THE VICTORIAN SOCIETY

25 March 2020

RE: Parkwood Methodist Church, Parkwood Road, Longwood, Huddersfield, HD3 4TT (Grade II, 1868): Listed Building Consent for alterations to convert former church to 12 residential units, formation of parking areas and widen vehicular access (within a Conservation Area).

Drawing No. 17-023-06

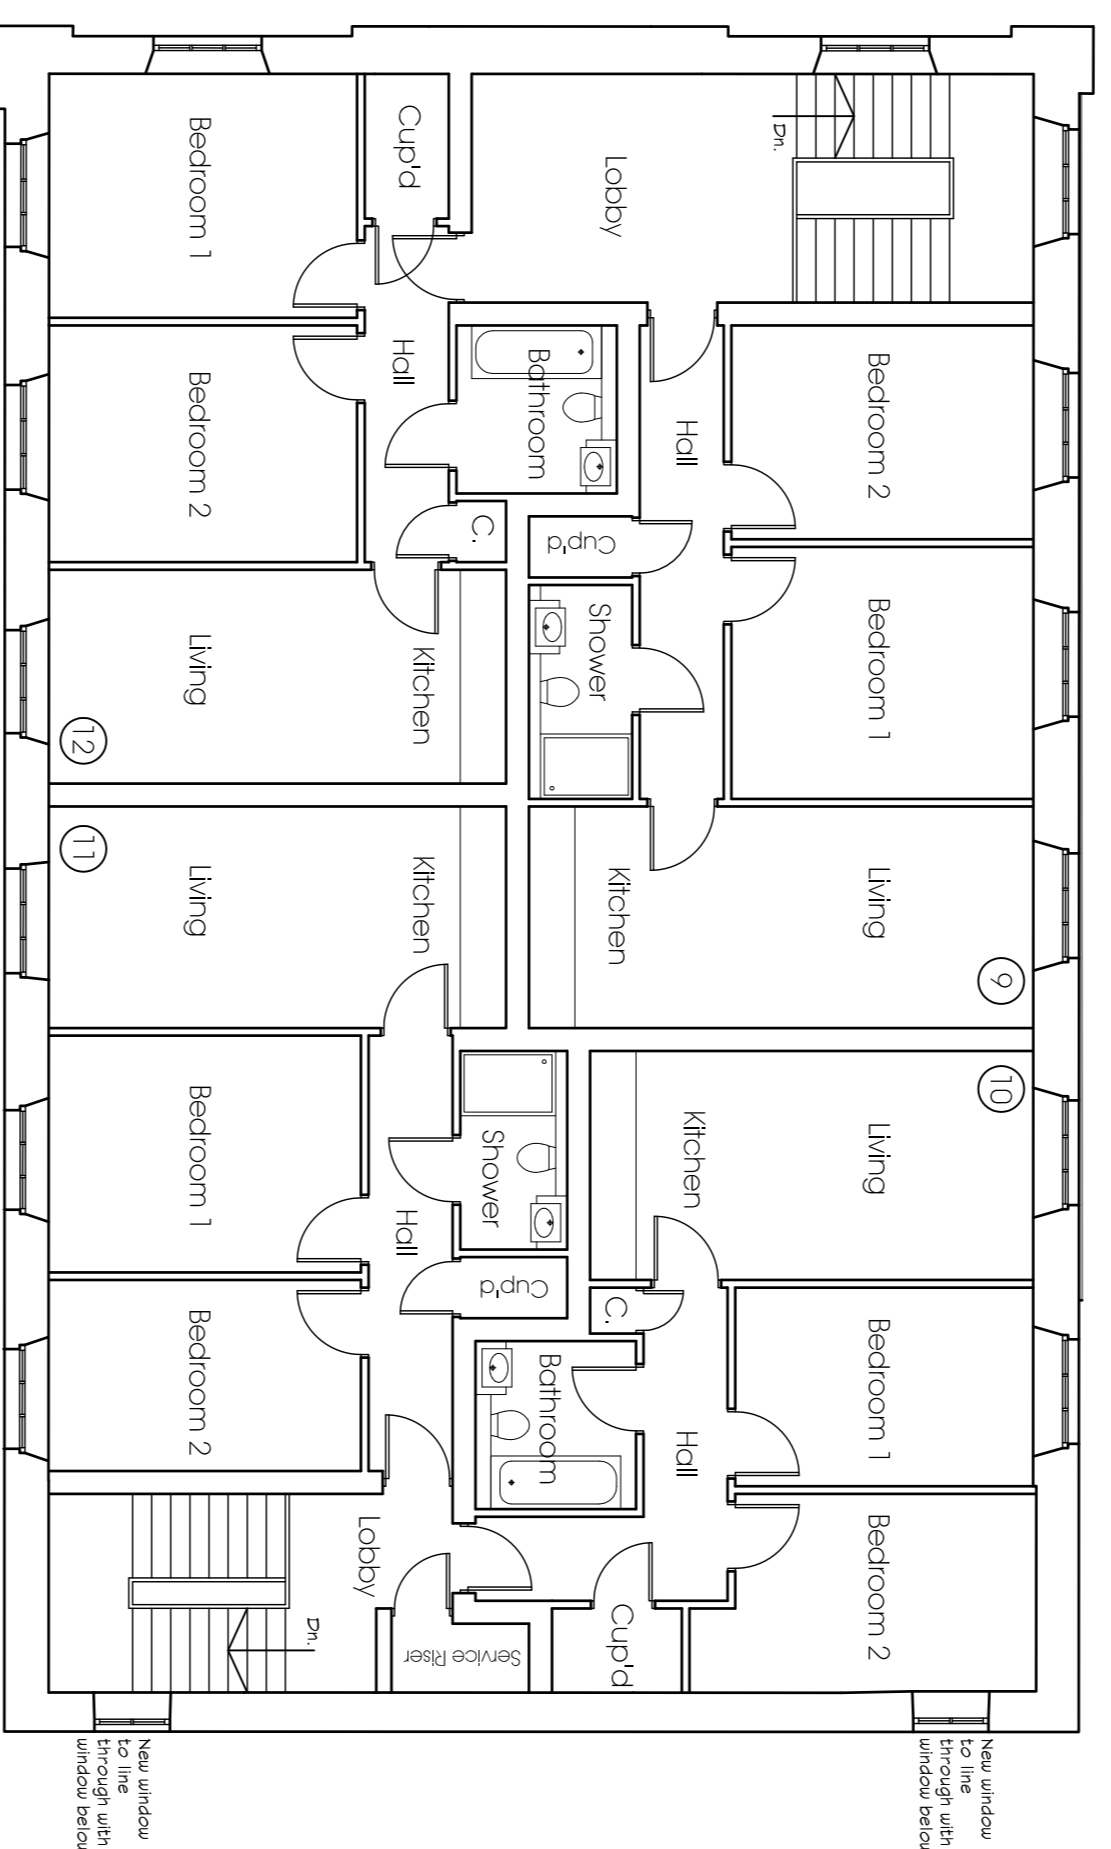
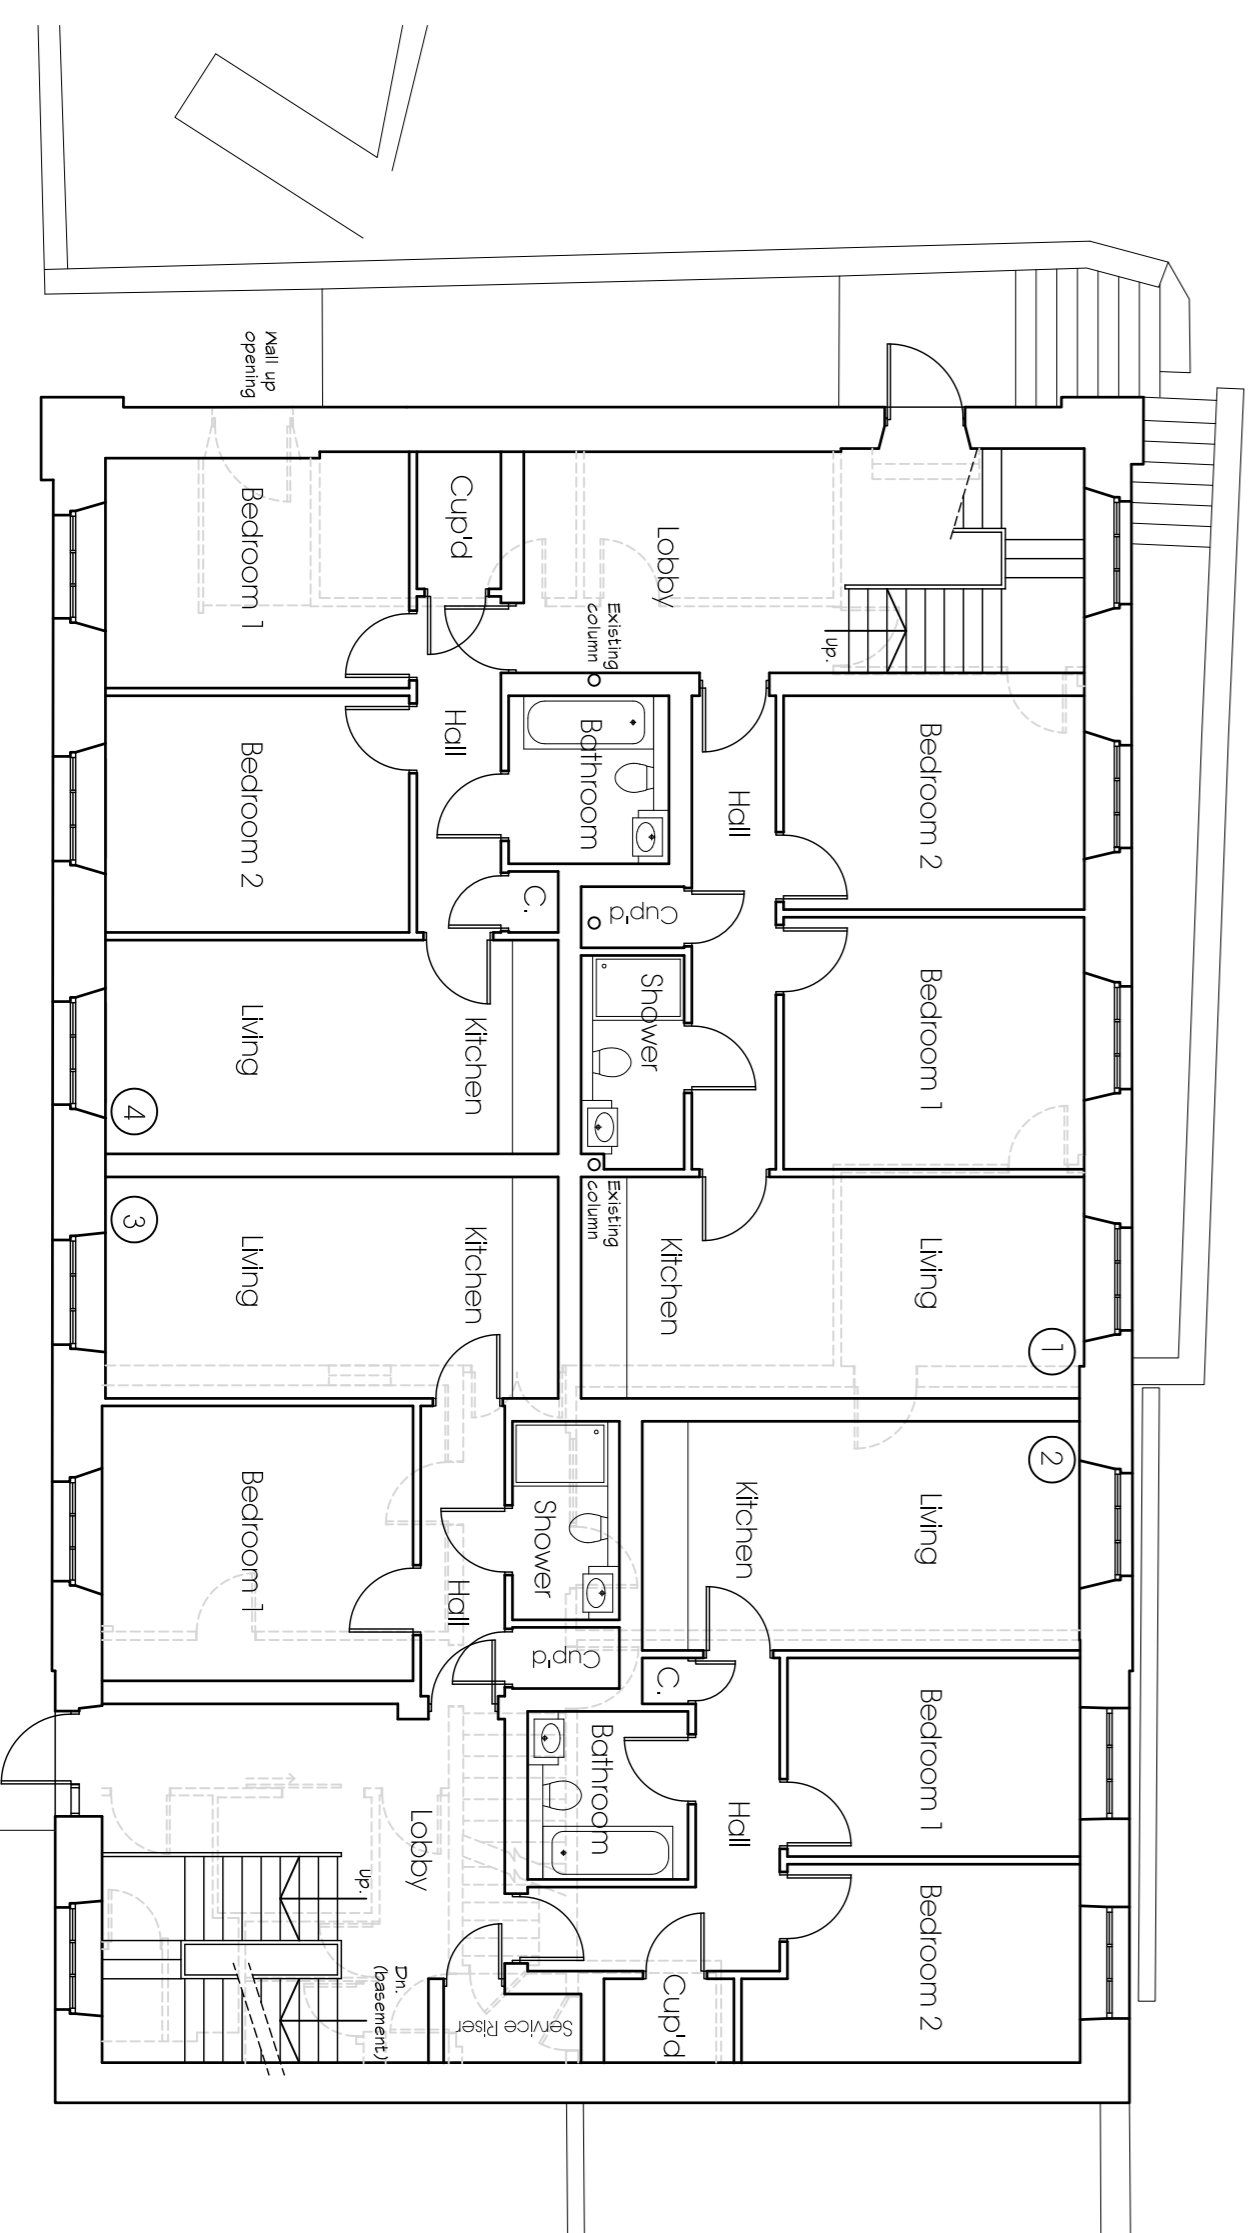
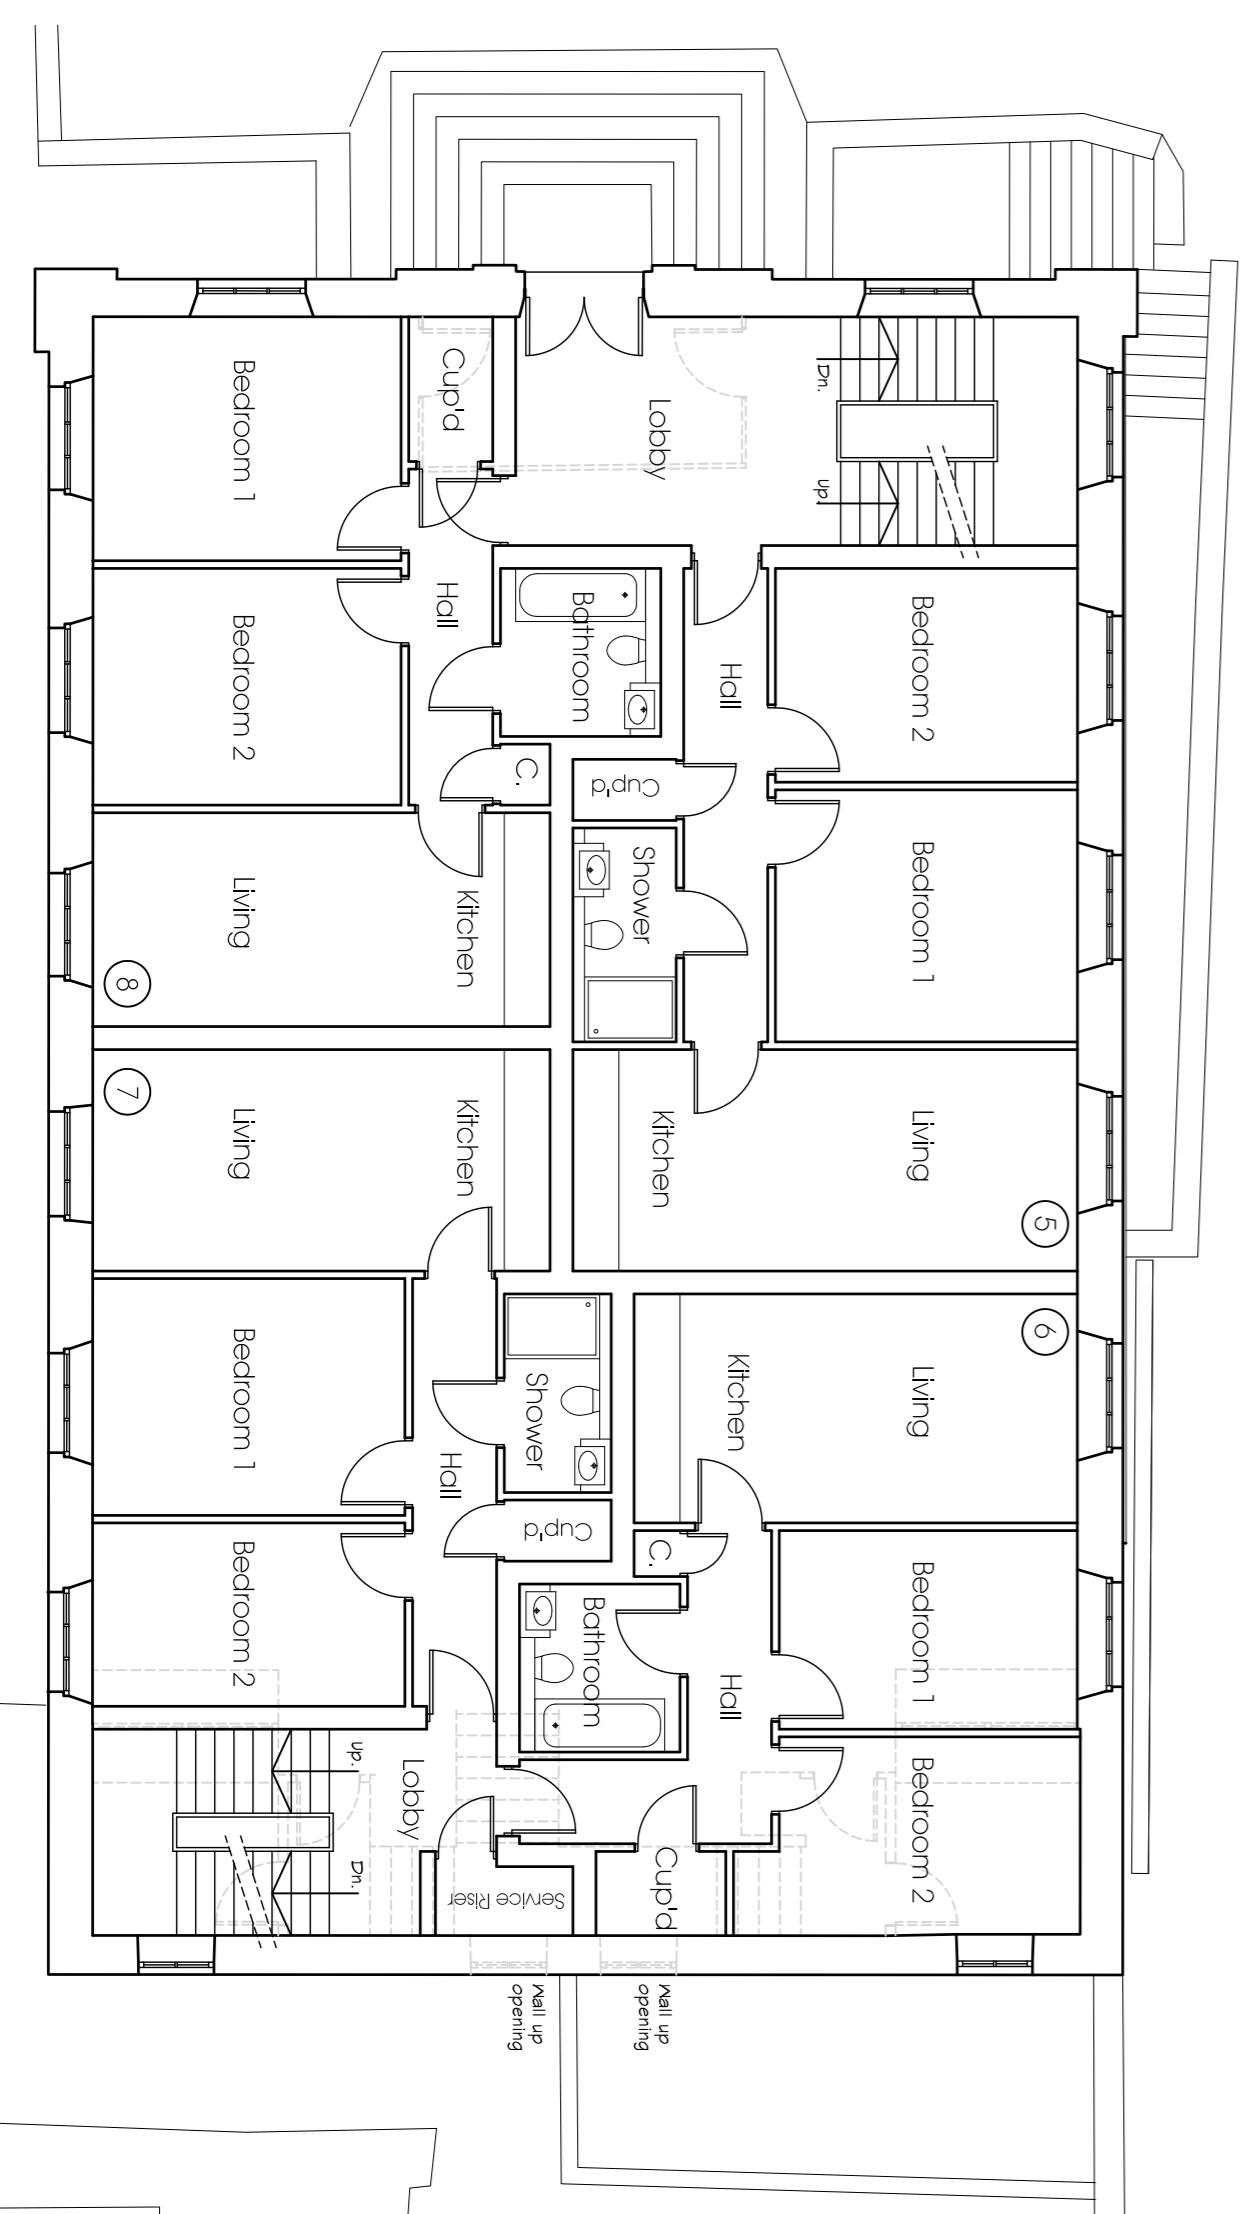
We must remind your authority that, unless explicitly excluded in the text of the list description under the amendments to the Planning (Listed Buildings and Conservation Areas) Act, 1990, s.1 5A a) and b), the interiors of a listed building are afforded the same protection as the exteriors. These proposals involve the total destruction of the interior of a listed church. The harm is both material and spatial: all the interior fixtures and fittings are to be removed, and the principal open space of the interior is to be heavily subdivided. Although the exterior is to be preserved mostly intact, we consider that this total loss of the historic interior will result in **substantial harm** to the significance of the building, and advise your authority to apply national policy accordingly.

Although we consider the substantial harm that the current proposals will cause to be a compelling reason for the refusal of consent, we must point out that the application is unacceptable in other respects. Whereas the total loss of the interior will clearly cause substantial harm it is possible that revised, less drastic proposals for the alteration and adaption of the existing interiors might be acceptable. If such revisions are to be submitted a nuanced understanding of the significance of the interiors will be vital for a balancing judgment to be made. Such an understanding will only be possible if a thorough assessment of significance is provided, in line with the requirements of the NPPF, paragraph 189. The current application entirely fails to meet these requirements, providing very scanty information about the interior and only a few photographs. We recommend that a thorough survey of the interior is undertaken by a heritage professional in order to assess the significance of the interior fittings in detail.
